Application for a non-material amendment following a grant of planning permission.
Town and Country Planning Act 1990

320130686P

PROPOSED ERECTION OF A NEW SPORTS HALL AND RE-ORIENTATION OF EXISTING TENNIS COURTS.

3/2012/0277

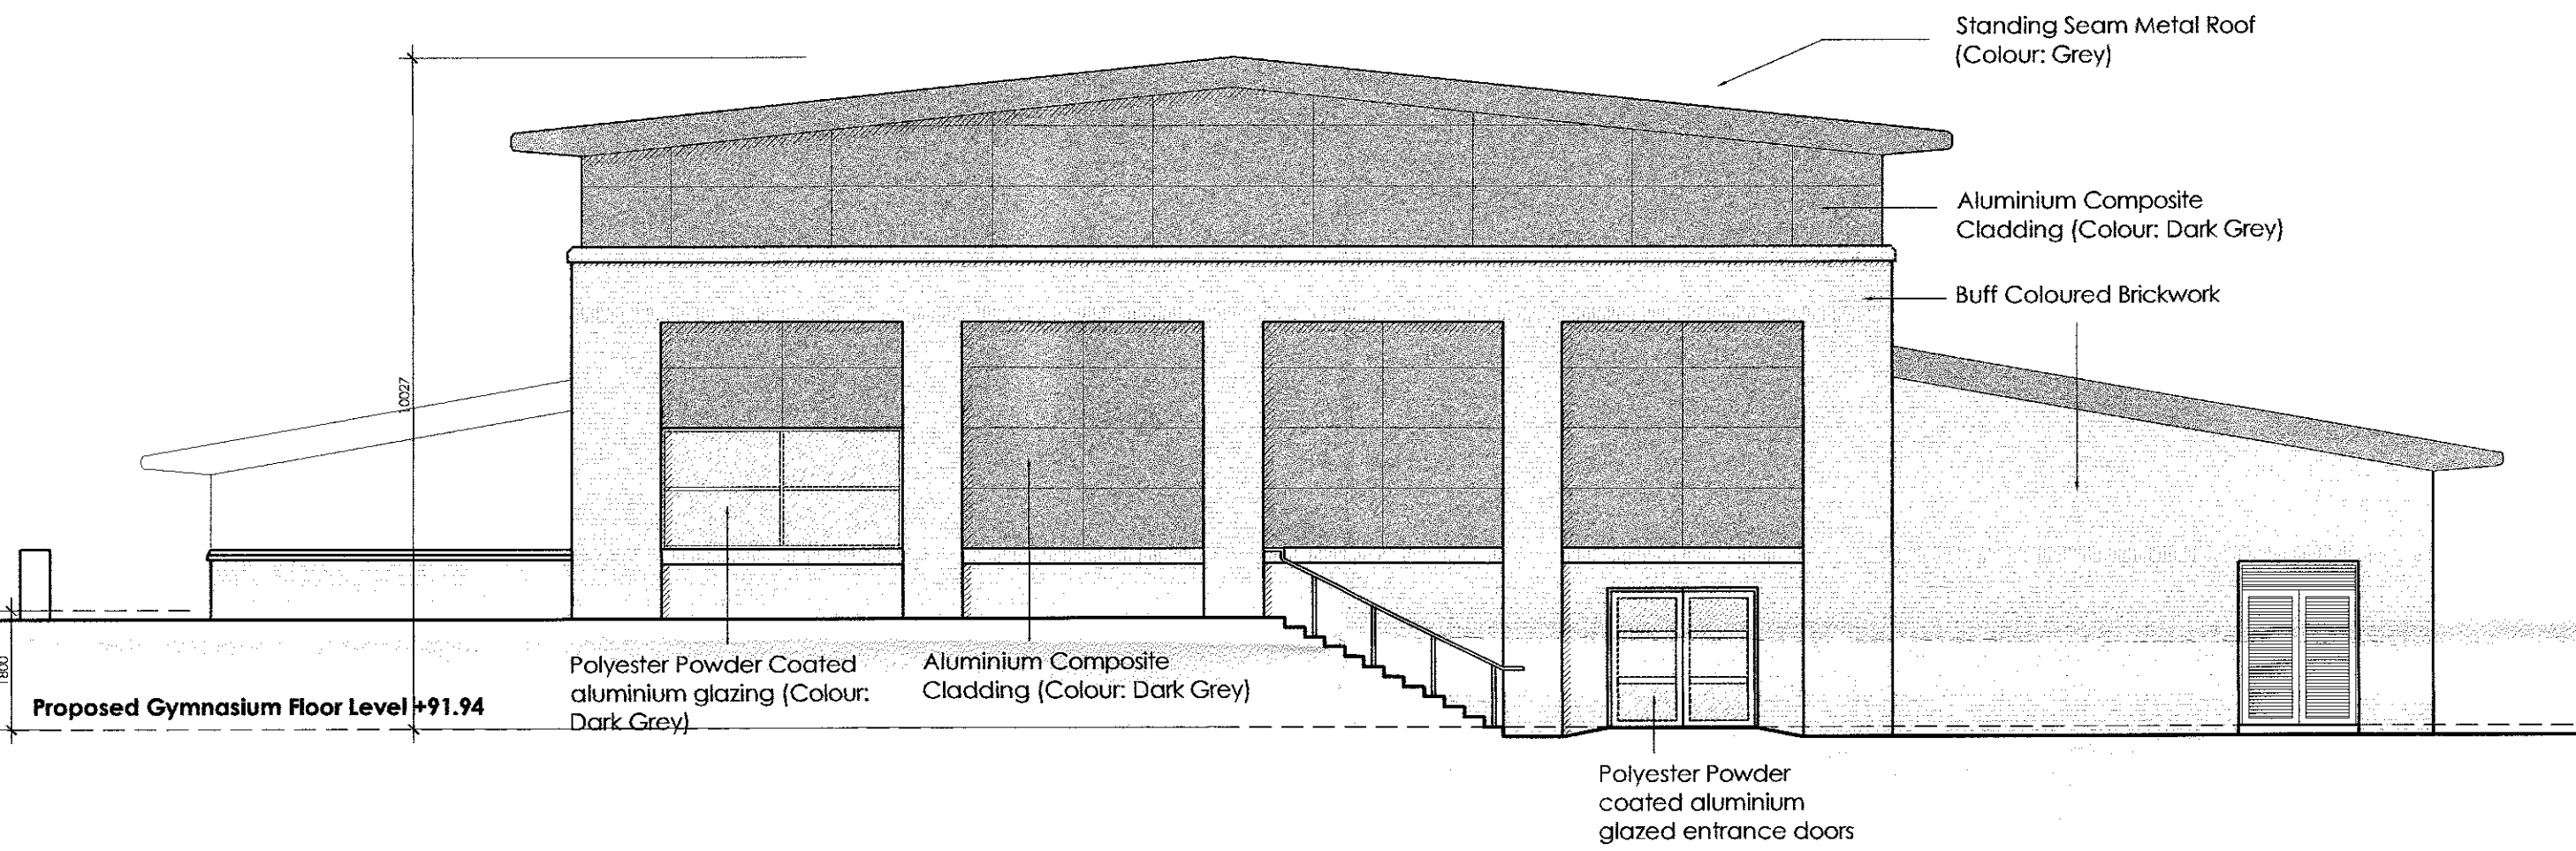
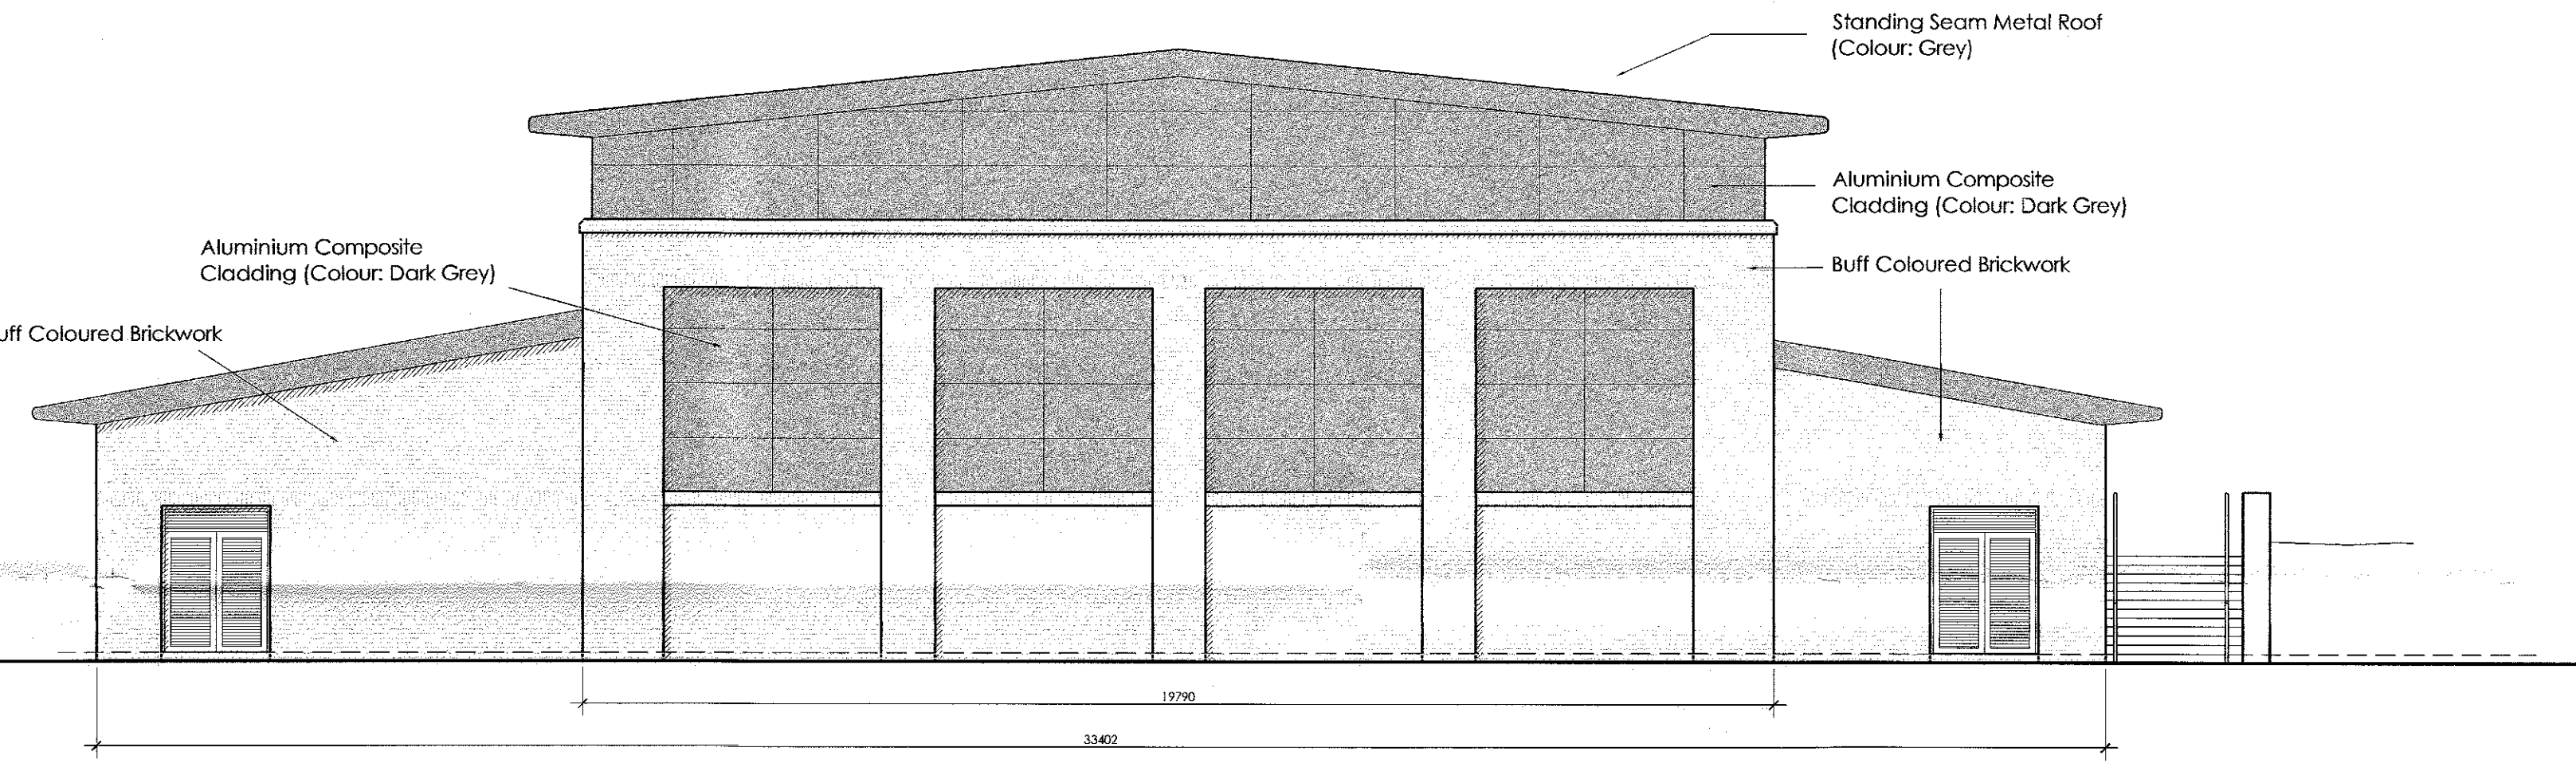
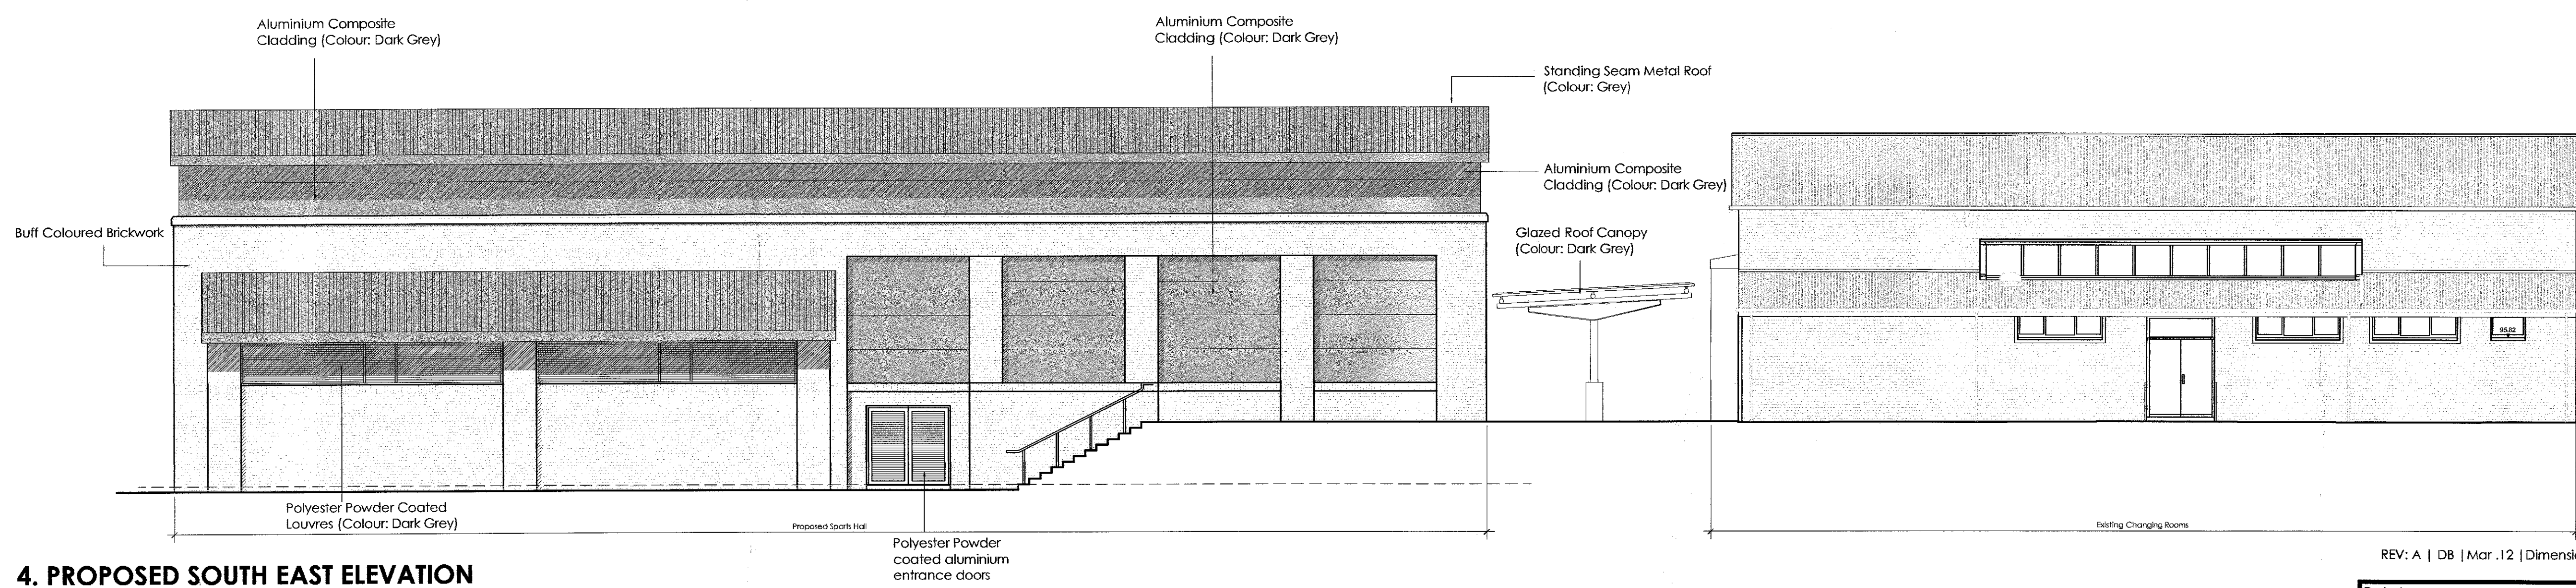
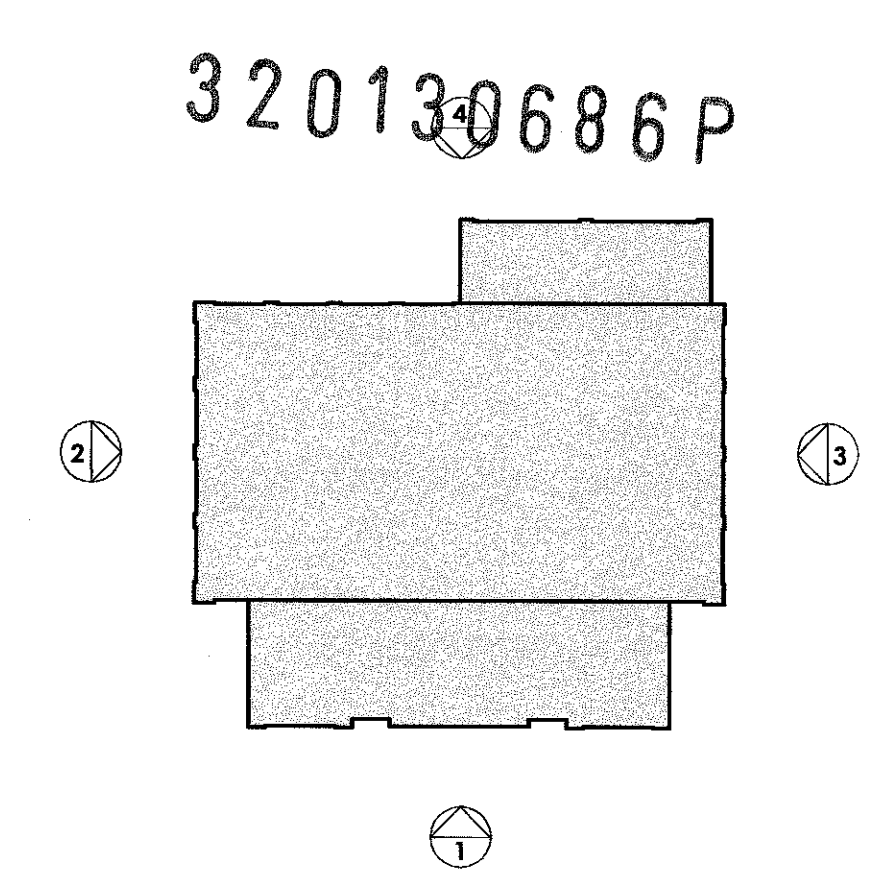
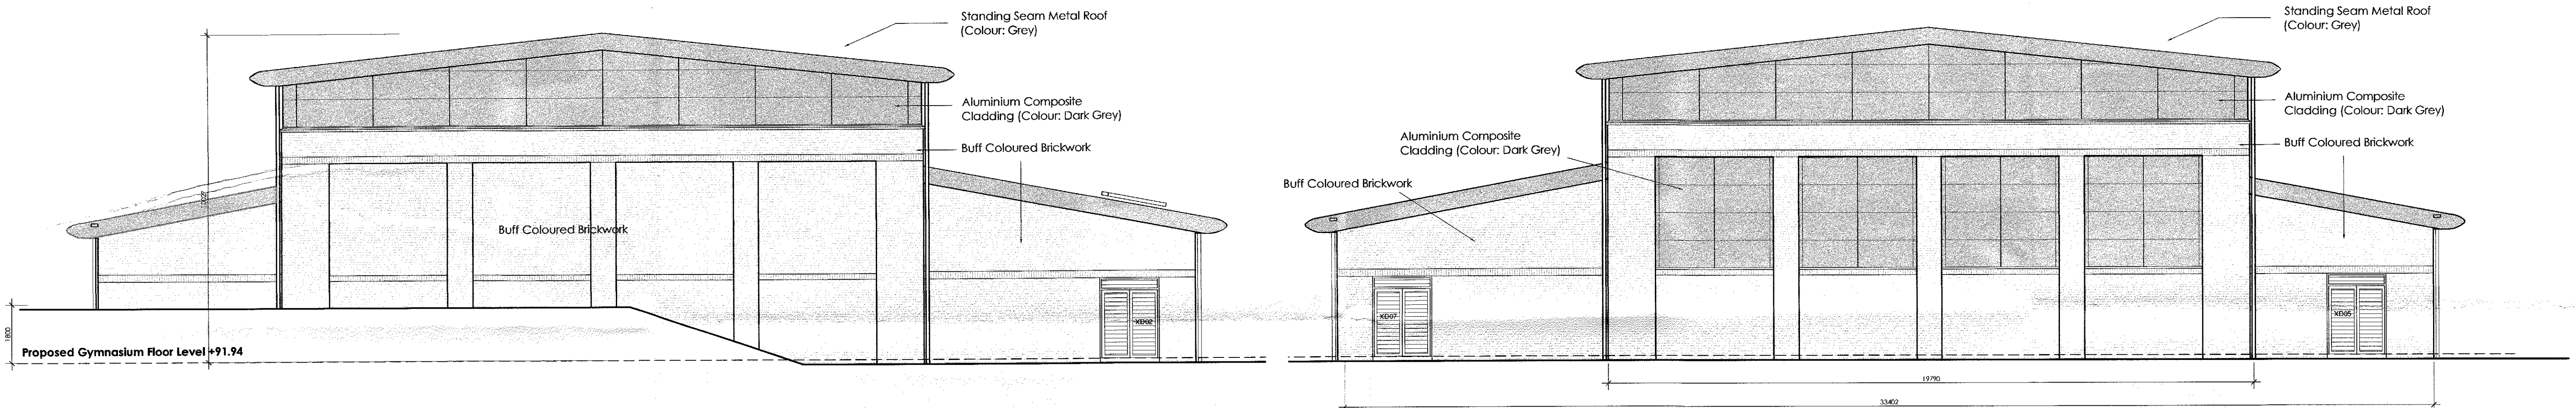
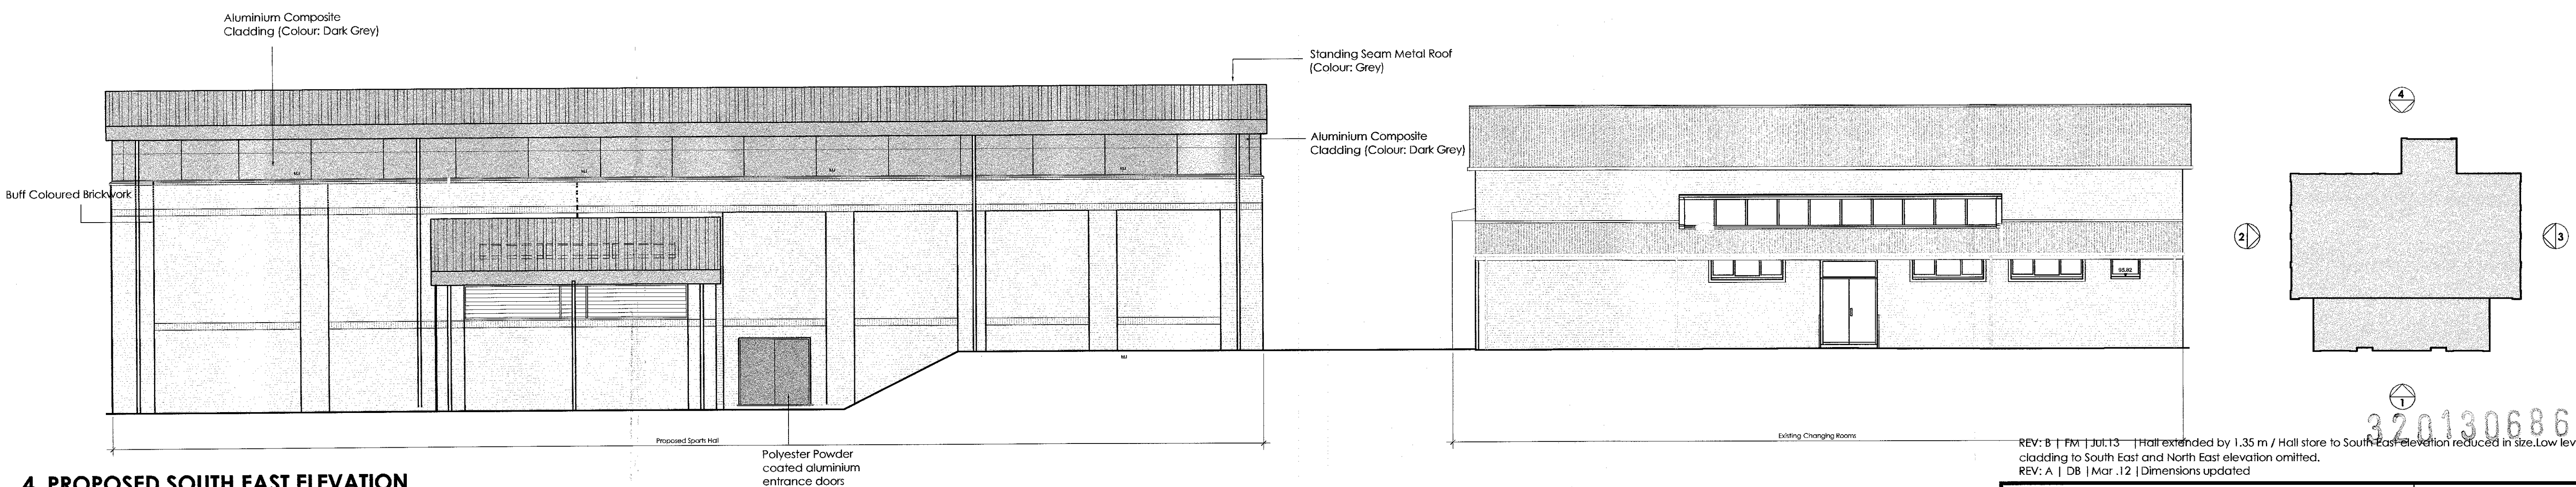
1. THE MAIN SPORTS HALL ZONE IS TO ENLARGE BY STRETCHING THE PLAN BY 1350MM TO ALLOW THE INCORPORATION OF RETRACTABLE SEATING. (ADDITIONAL _____MSQ).
2. THE SINGLE STOREY SPORTS HALL TO THE SOUTH EAST ELEVATION IS TO BE REDUCED IN SIZE (REDUCTION _____MSQ).
3. THE LOW LEVEL ALUMINIUM RAINSCREEN CLADDING PANELS TO THE SOUTH EAST AND NORTH EAST ELEVATION ARE TO BE OMITTED.
4. THE EXTERNAL WORKS PROPOSALS HAVE BEEN RATIONALISED.

THE PROPOSED ALTERATIONS TO THE APPROVED SCHEME HAVE ARISEN FOLLOWING THE CLIENT REQUEST TO INTRODUCE RETRACTABLE SEATING WITHIN THE SPORTS HALL AREA. IN ORDER TO MAINTAIN MINIMUM SITE STANDARDS WITHIN THE HALL THIS HAS NECESSITATED THE ENLARGING OF THE HALL BY STRETCHING THE HALL BY 1350MM ON THE SOUTH WEST ELEVATION. AT THE SAME TIME THE SINGLE STOREY HALL STORE HAS BEEN REDUCED IN SIZE TO CREATE AN OVERALL NET REDUCTION IN FLOOR AREA FROM THE APPROVED SCHEME.
